**Consultation Response from KC,
Conservation & Design****2023/92712 Land adjacent, 36 Oxford Road, Dewsbury, WF13 4LL****Erection of 40 bed care home and 12 independent supported living units (use class C2) with associated works including the formation of car park and service access****Date Responded: 26.10.2023****Responding Officer: S Pickles****Responding Ref:**

Status:	PLANNING	A3
Client:	Thomas Owen Care	
Project:	Fredrick Finlay Oxford Road, Dewsbury	
Title:	Proposed Roof Plan	
Drawn:	AMN	Date: August 2023
Check:	NC	Scale: 1 : 250 @A1
Information Name:		Rev:
410004-FCA-01-ZZ-DR-A-		P01

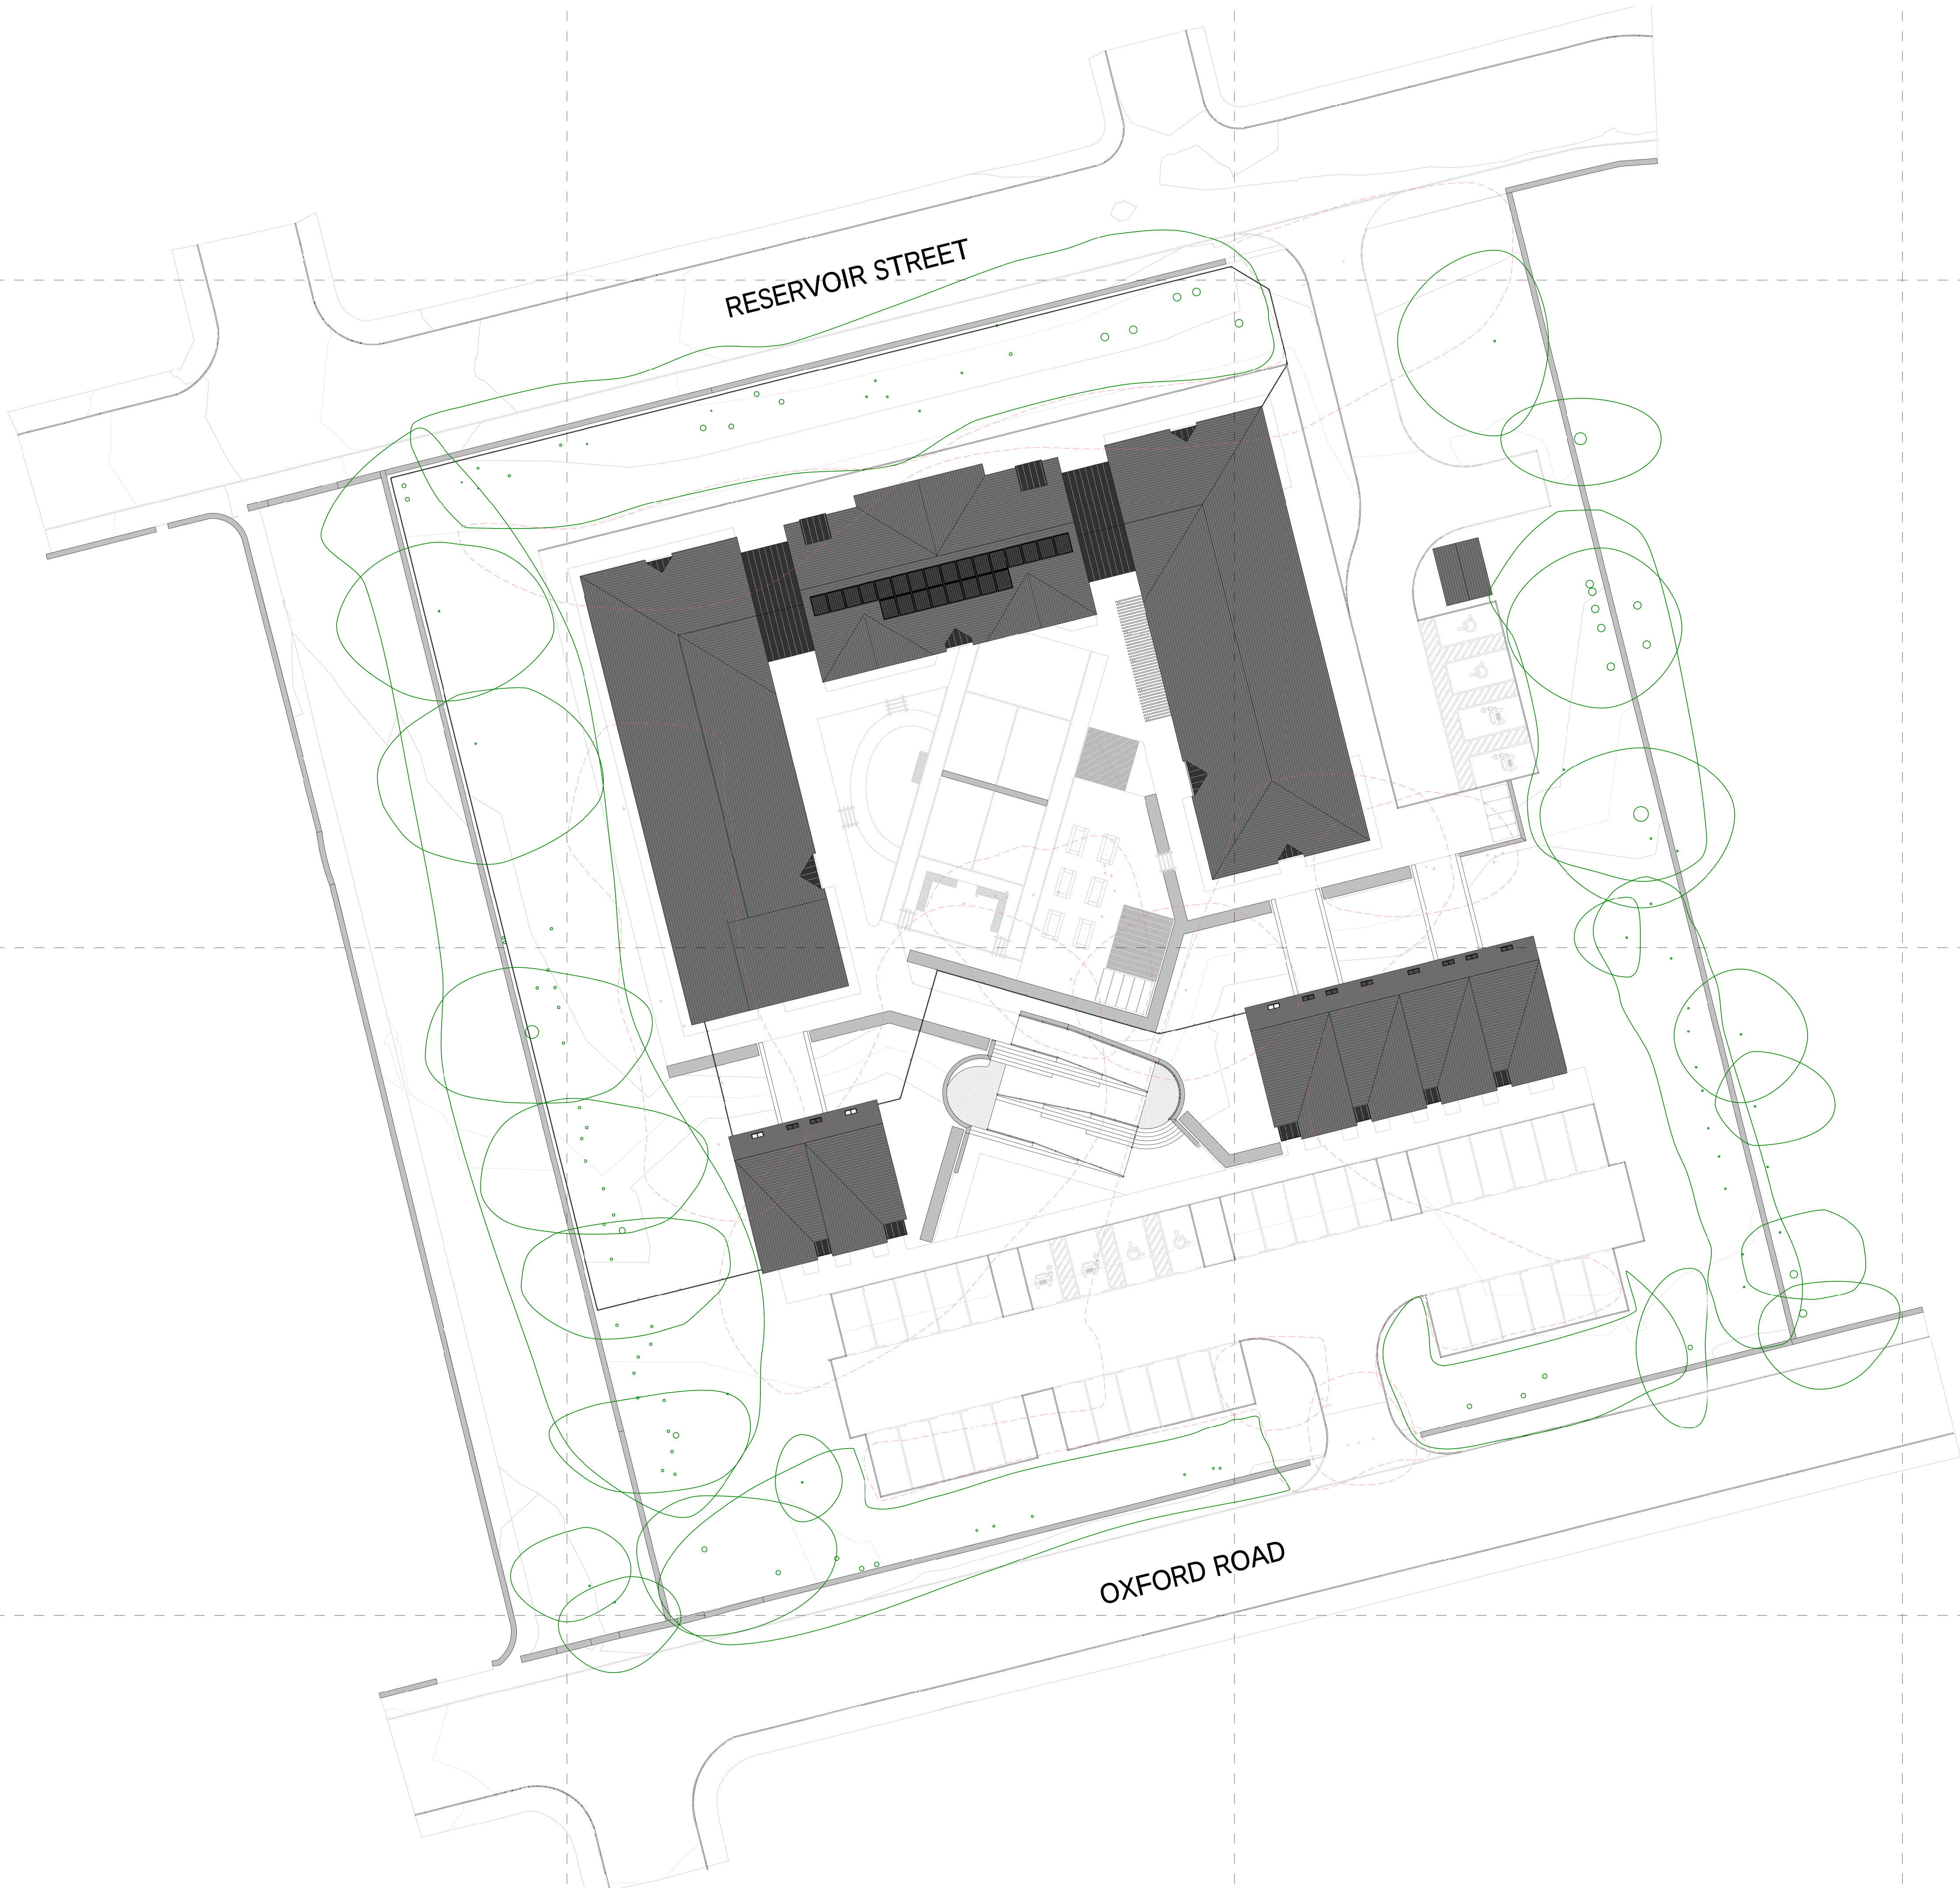
The plans also state that the roofs are to be finished with interlocking tiles. We set out at pre-app stage that the roof should be finished in natural slates. This would have a more appropriate finish and ensure a high-quality finish.

PROPOSED NORTH ELEVATION - COURT 02
1 : 100

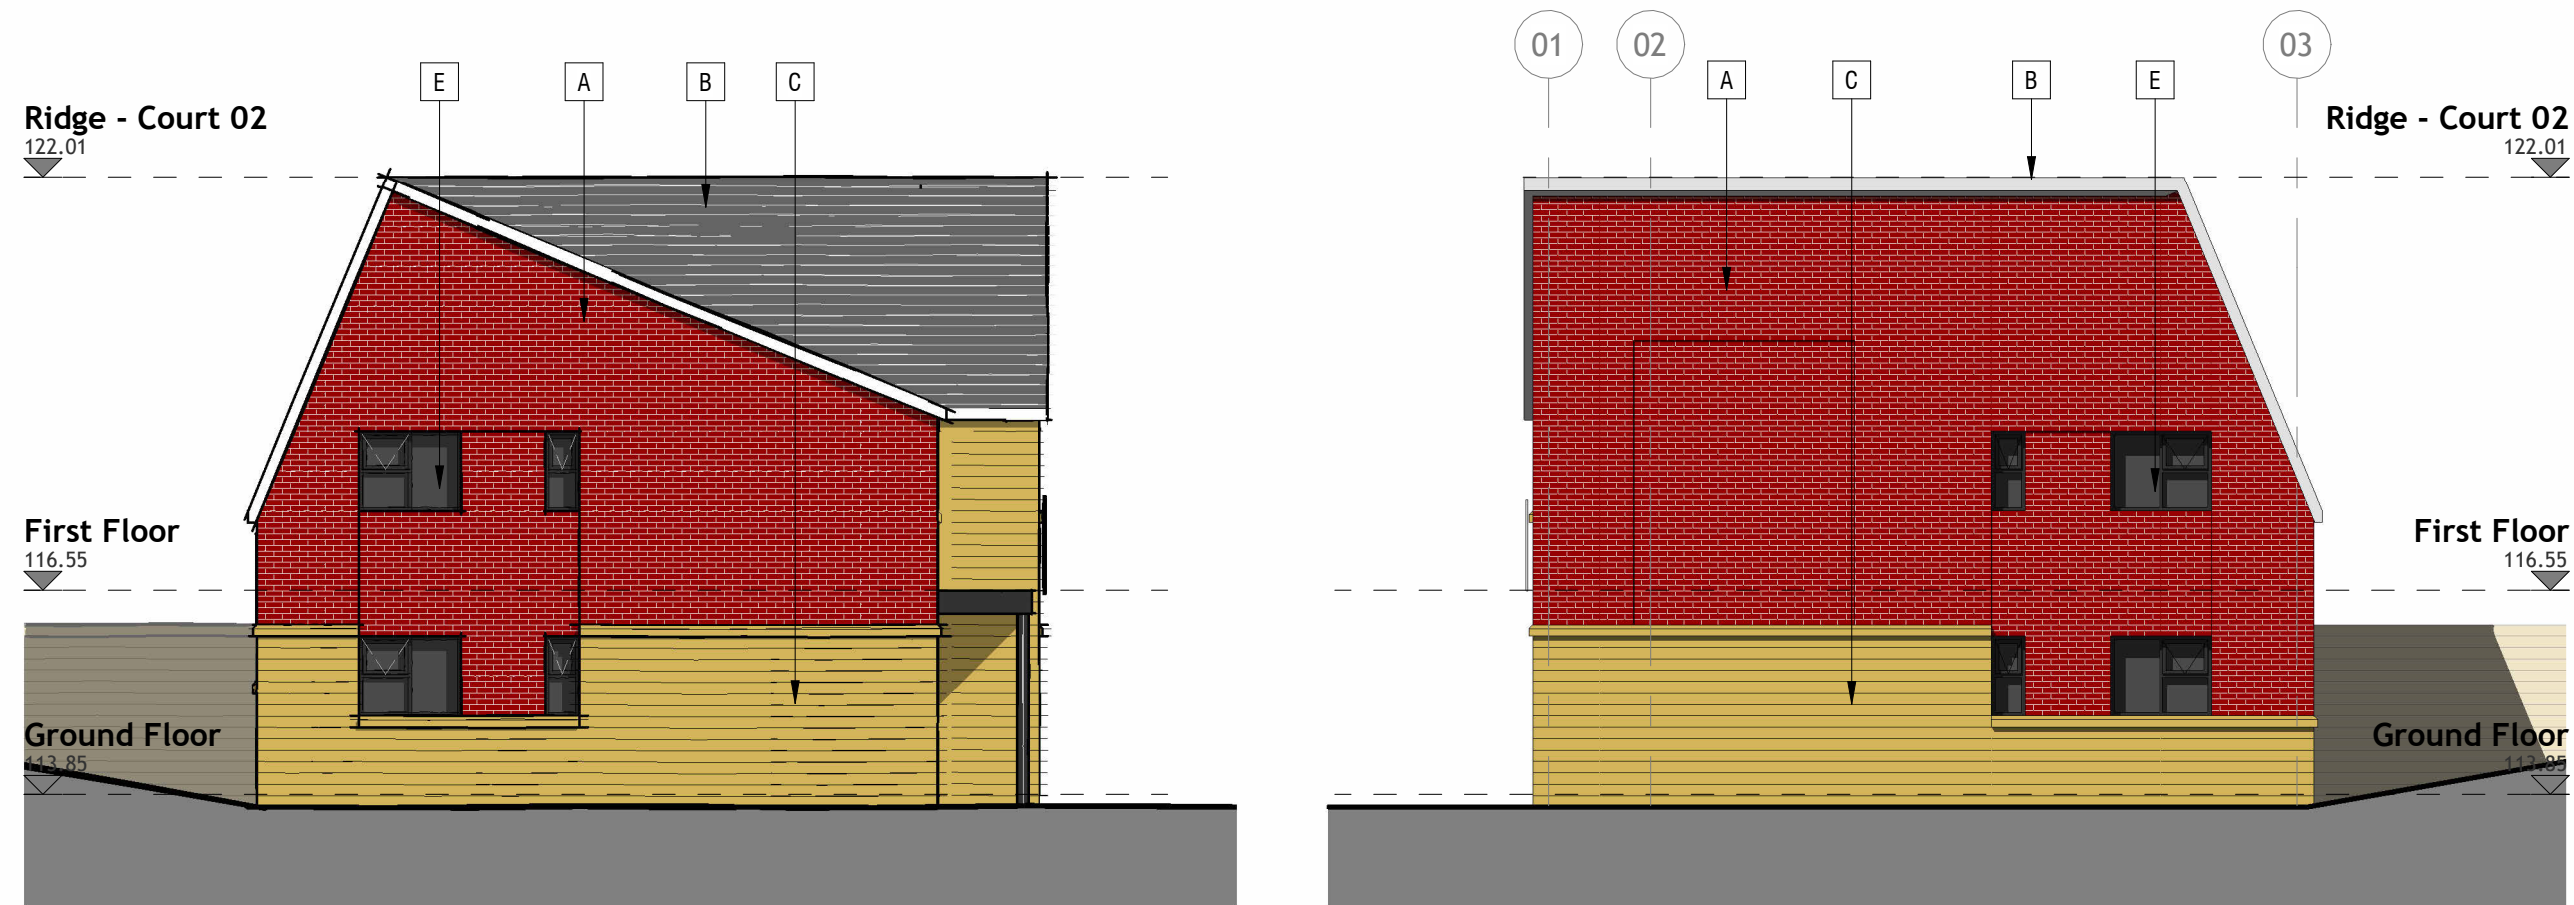
One of the main material changes is the introduction of buff red brick to the elevational treatment. We set out in our pre-application comments that materials should be natural local stone and natural roof slates. Within the supporting details, it sets out that the materials have been well considered and look to reflect the character of the area.

We consider that the plans need to be amended to remove the use of the buff red brick and make use of natural stone only. While we understand the rationale behind the use of red brick as a means of

breaking up the elevation, this could be achieved with the use of alternatively faced stone. The split-faced stone could be used for either the upper or lower levels and then either ashlar, thinner course stone or an alternative finish could be used for the other level. Additionally, it is noted that there is the use of a stone string course on the buildings, which could be accentuated and given some additional detail, which would also assist in breaking up the elevations.
